Proposed Immingham Eastern Ro-Ro Terminal, Port of Immingham

HSE's Relevant Representation – PINS ref:TR030007

Application by Associated British Ports for an Order Granting Development Consent for the Immingham Eastern Ro-Ro Terminal (TR030007)

Drawing title
**GENERAL ARRANGEMENT PLANS
 JETTY & NORTHERN YARD
 REGULATION 5(2)(o) & 5(2)(k)
 SHEET 2 OF 5**

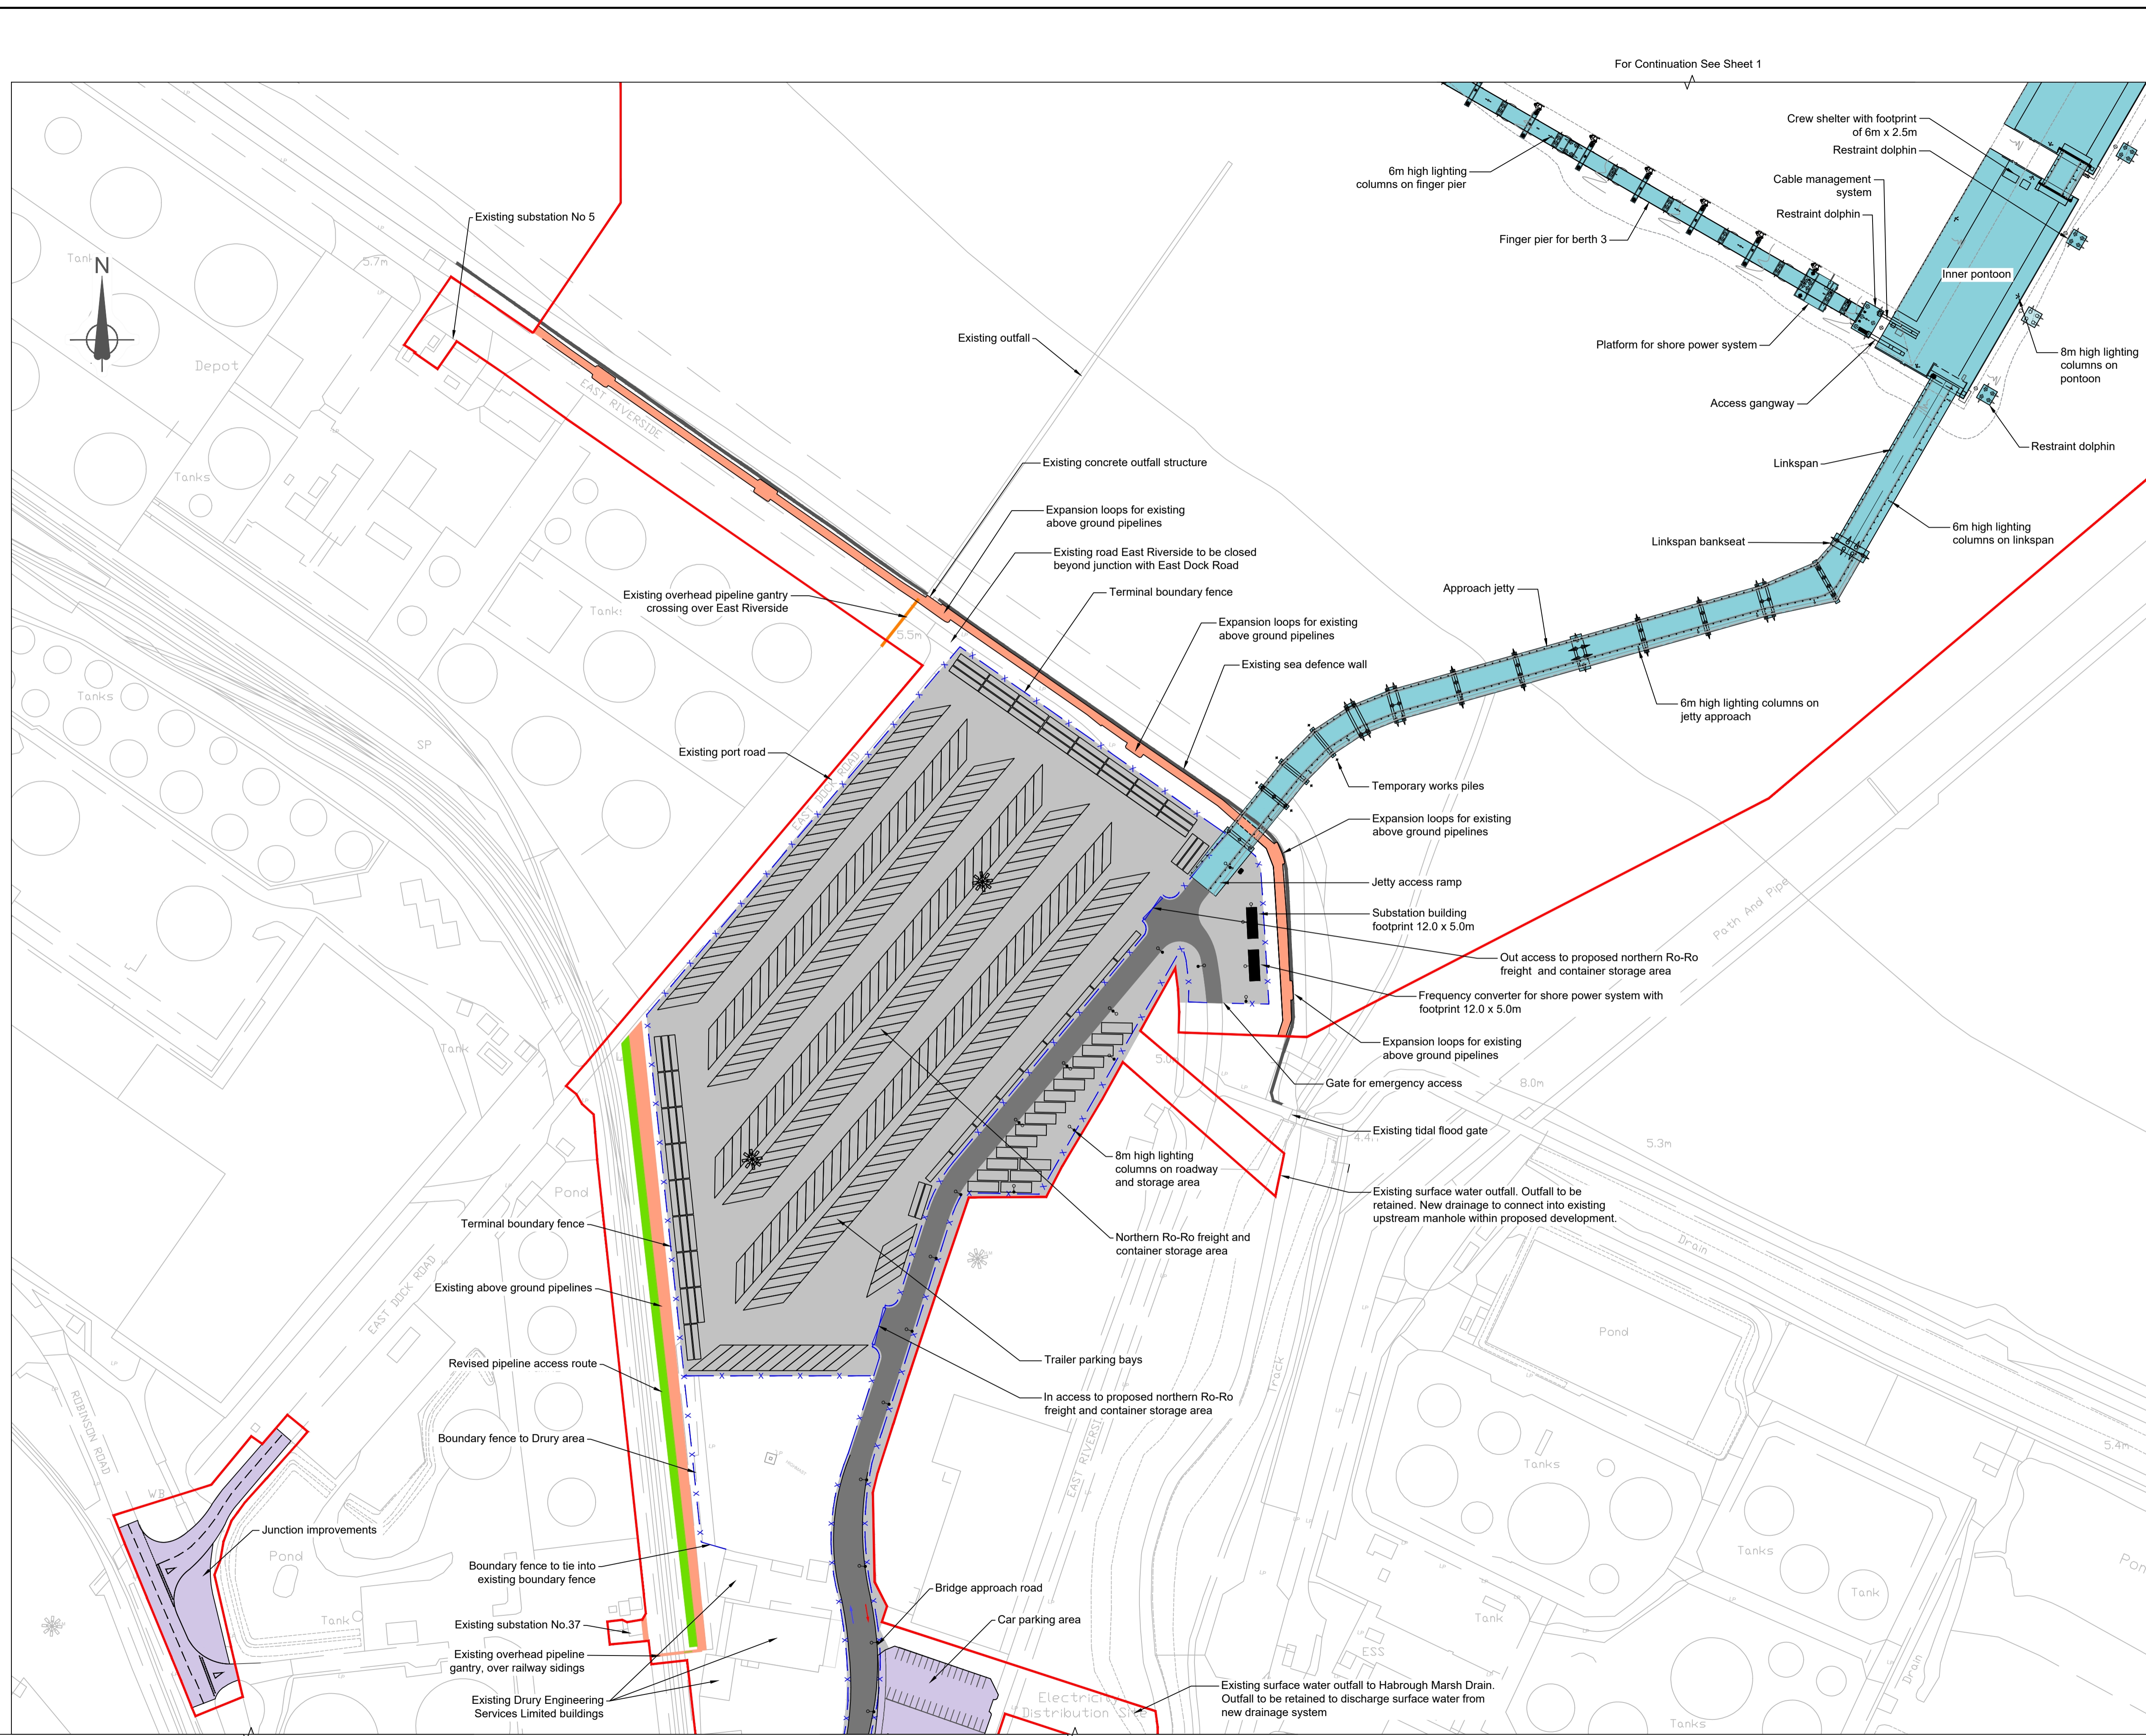
- a) **Northern Storage Area** - This is situated partly inside a DPZ which surrounds the Exolum tank farm, as can be seen in the attached image. The layout as presented indicates slots for trailer and container laydown points (the small rectangles). No buildings will be constructed in that area which will simply remain in use for the storage of cargo in transit – as is the case today. We trust you agree from the plan that the DPZ around the Immingham Oil Terminal's tank farm, seen to the southeast, does not overlap the IERRT boundary in any meaningful way.

13. ABP's confirmation on the locations of people is in three parts a) to c), screenshots reproduced as follows:
- a) **Northern Storage Area** - This is situated partly inside a DPZ which surrounds the Exolum tank farm, as can be seen in the attached image. The layout as presented indicates slots for trailer and container laydown points (the small rectangles). No buildings will be constructed in that area which will simply remain in use for the storage of cargo in transit – as is the case today. We trust you agree from the plan that the DPZ around the Immingham Oil Terminal's tank farm, seen to the southeast, does not overlap the IERRT boundary in any meaningful way.

16. HSE confirms that the clarity provided from ABP's letter and drawings, which will form part of the NSIP application, that applying HSE's land-use planning methodology would **not** advise against the Proposed Development in this configuration.

Drawing title
GENERAL ARRANGEMENT PLANS SOUTHERN & CENTRAL AREAS & WORKSHOP AREA REGULATION 5(2)(o) & 5(2)(k) SHEET 4 OF 5

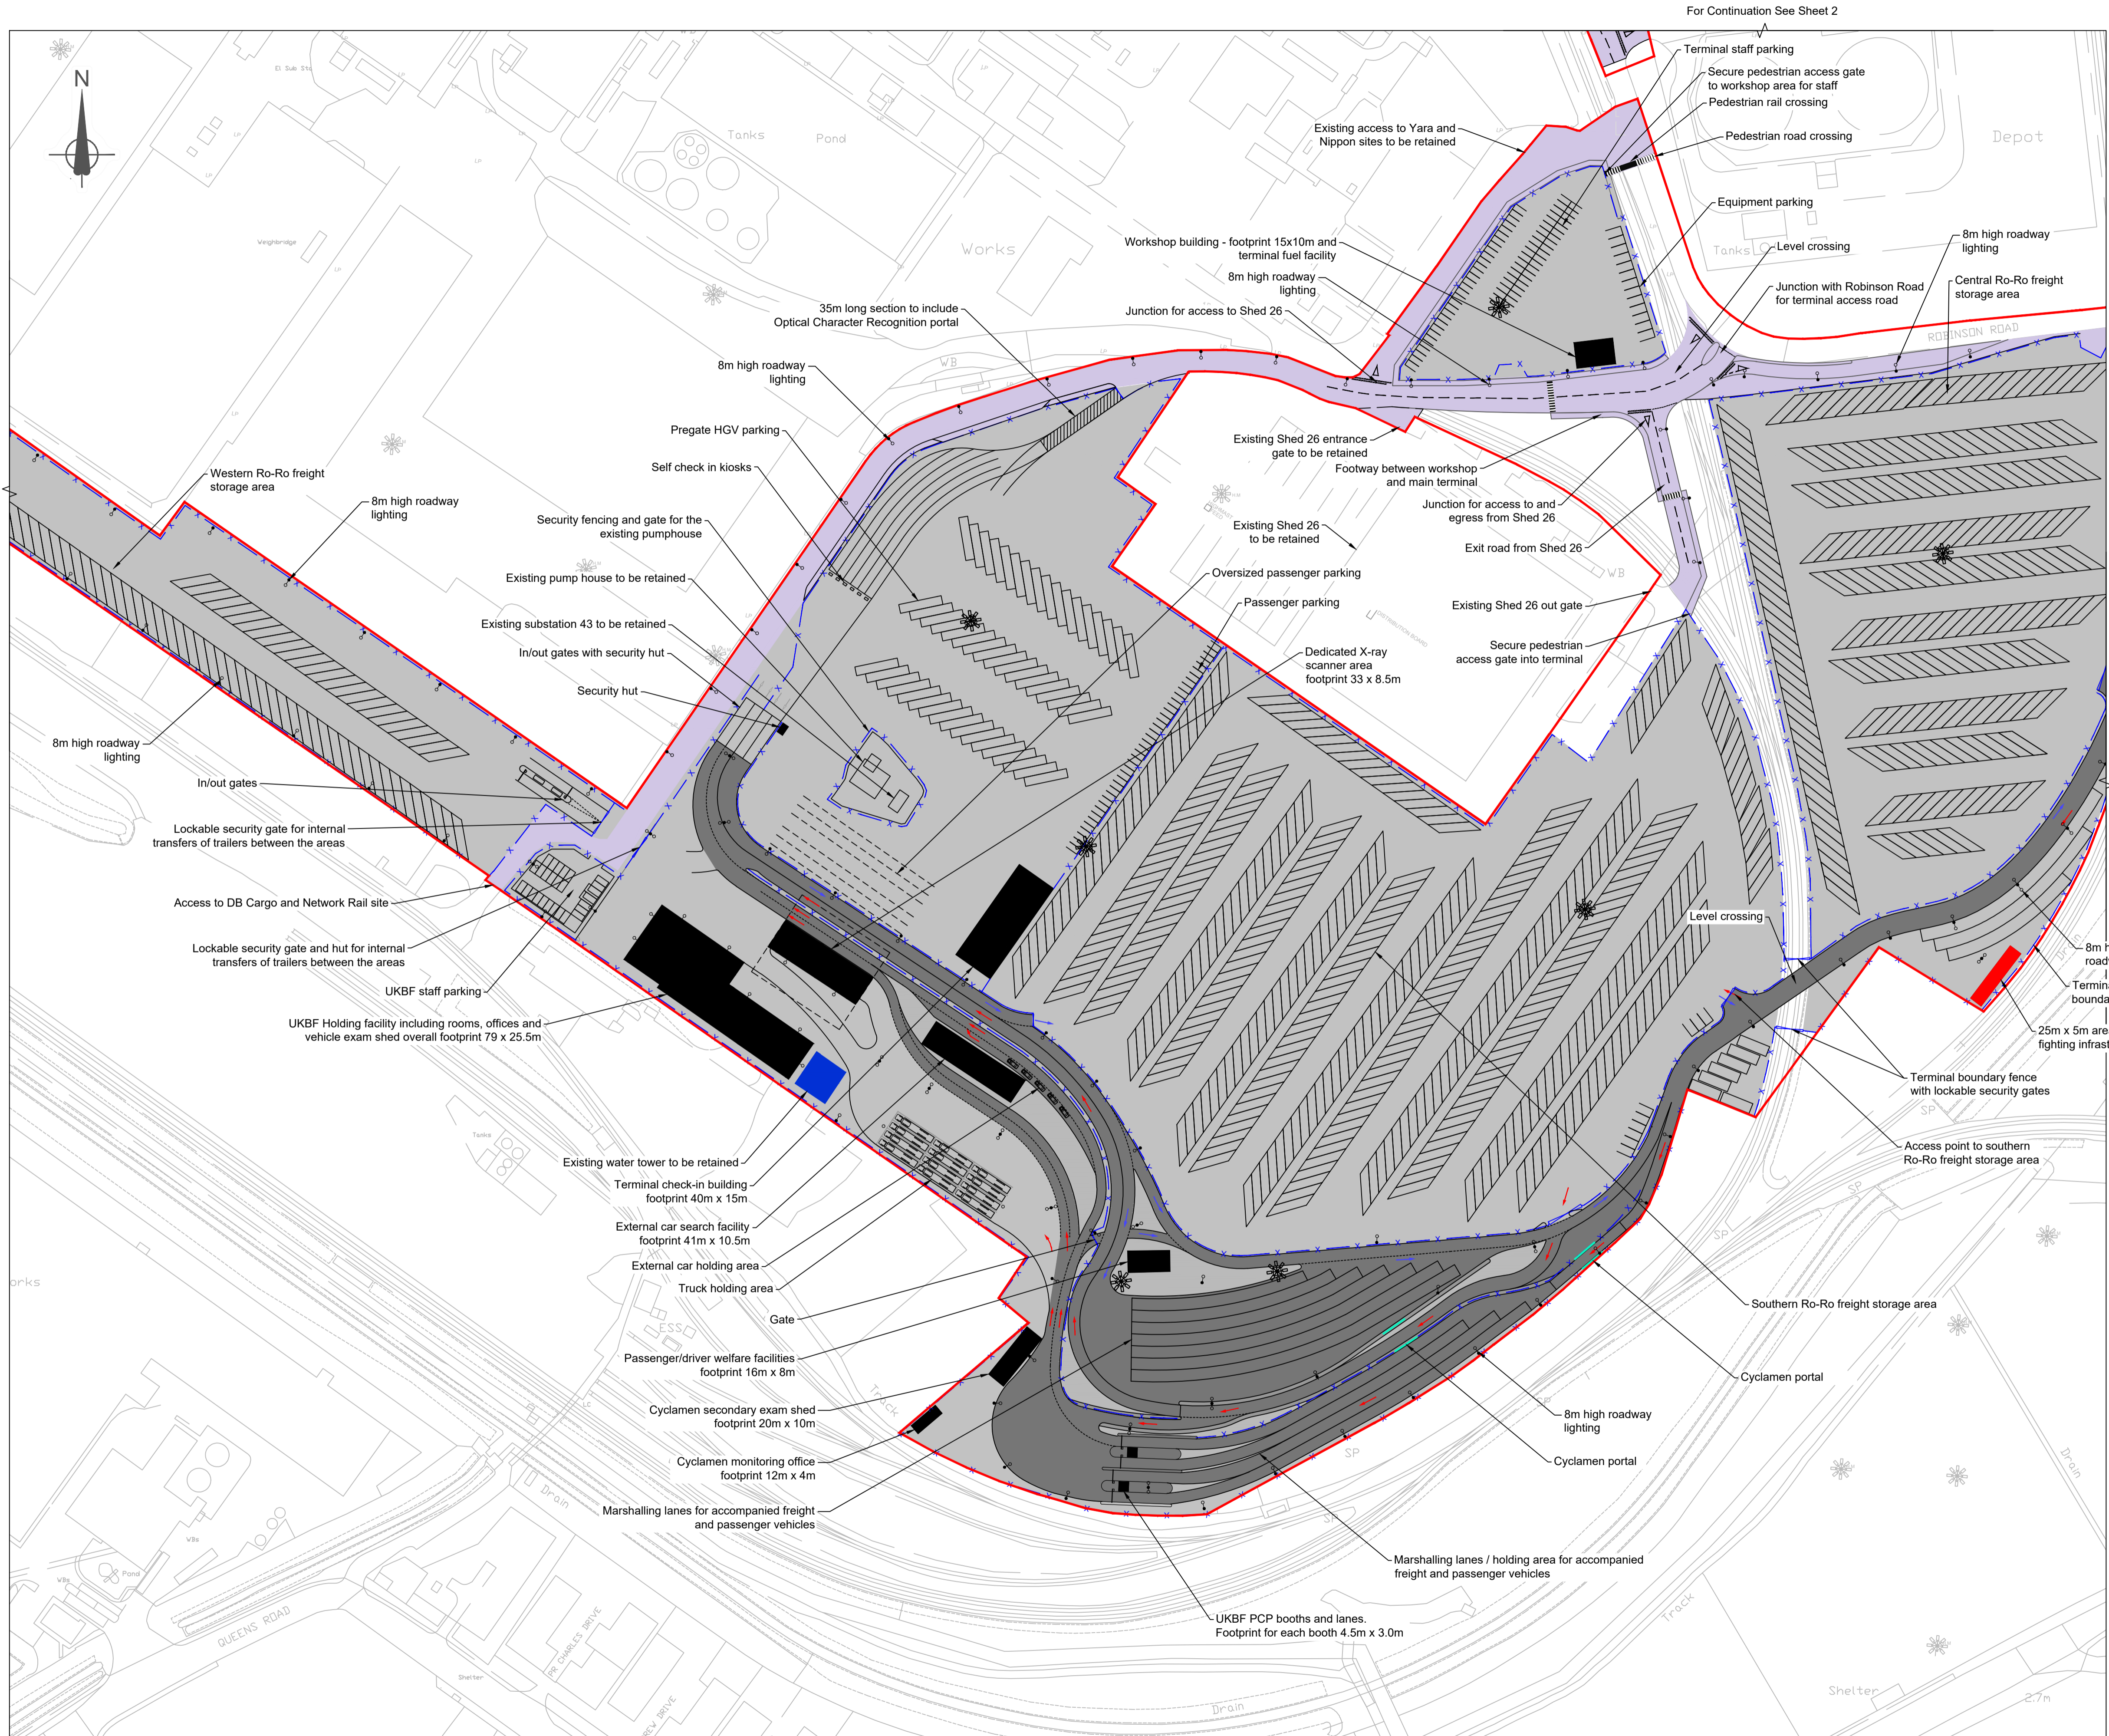
- c) **Passenger waiting area** – This area has been located in the far south-eastern corner of the proposed new terminal area – immediately south of the Southern Storage Area. As you can see from the Plan, the area presents as curved waiting lanes (labelled as marshalling lanes) with a small welfare building. This area will accommodate separately, lorry drivers who are accompanying their cargo and a maximum number (as prescribed in the draft DCO) of 100 passengers in cars or recreational vehicles – as when there is available capacity. This passenger waiting area falls within a Middle Zone which we understand is acceptable subject to that strict limitation of no more than 100 passengers. In practical terms, car passengers will drive through Inner Zones to get to the terminal. They will stop at the main terminal office for a short duration to check-in for the sailing and will then be instructed to proceed to the 'in-gates' leading to the passenger waiting area. This area includes a passenger welfare building and marshalling lanes where passengers

will await instruction to board the vessel. As you will appreciate, apart from checking-in, passengers will necessarily spend the vast majority of their time waiting within the delineated waiting area, inside the middle zone – which will be enclosed by a fence.

- c) **Passenger waiting area** – This area has been located in the far south-eastern corner of the proposed new terminal area – immediately south of the Southern Storage Area. As you can see from the Plan, the area presents as curved waiting lanes (labelled as marshalling lanes) with a small welfare building. This area will accommodate separately, lorry drivers who are accompanying their cargo and a maximum number (as prescribed in the draft DCO) of 100 passengers in cars or recreational vehicles – as when there is available capacity. This passenger waiting area falls within a Middle Zone which we understand is acceptable subject to that strict limitation of no more than 100 passengers. In practical terms, car passengers will drive through Inner Zones to get to the terminal. They will stop at the main terminal office for a short duration to check-in for the sailing and will then be instructed to proceed to the 'in-gates' leading to the passenger waiting area. This area includes a passenger welfare building and marshalling lanes where passengers will await instruction to board the vessel. As you will appreciate, apart from checking-in, passengers will necessarily spend the vast majority of their time waiting within the delineated waiting area, inside the middle zone – which will be enclosed by a fence.

14. I also attach two drawings from ABP that they have referenced in their response. These show overlays of HSE's land-use planning zones on the plans of the Proposed Development where yellow, red, green, and blue are the DPZ, inner, middle and outer zones respectively (in order of descending risk). HSE would not advise against 100 passengers in the green shaded areas.
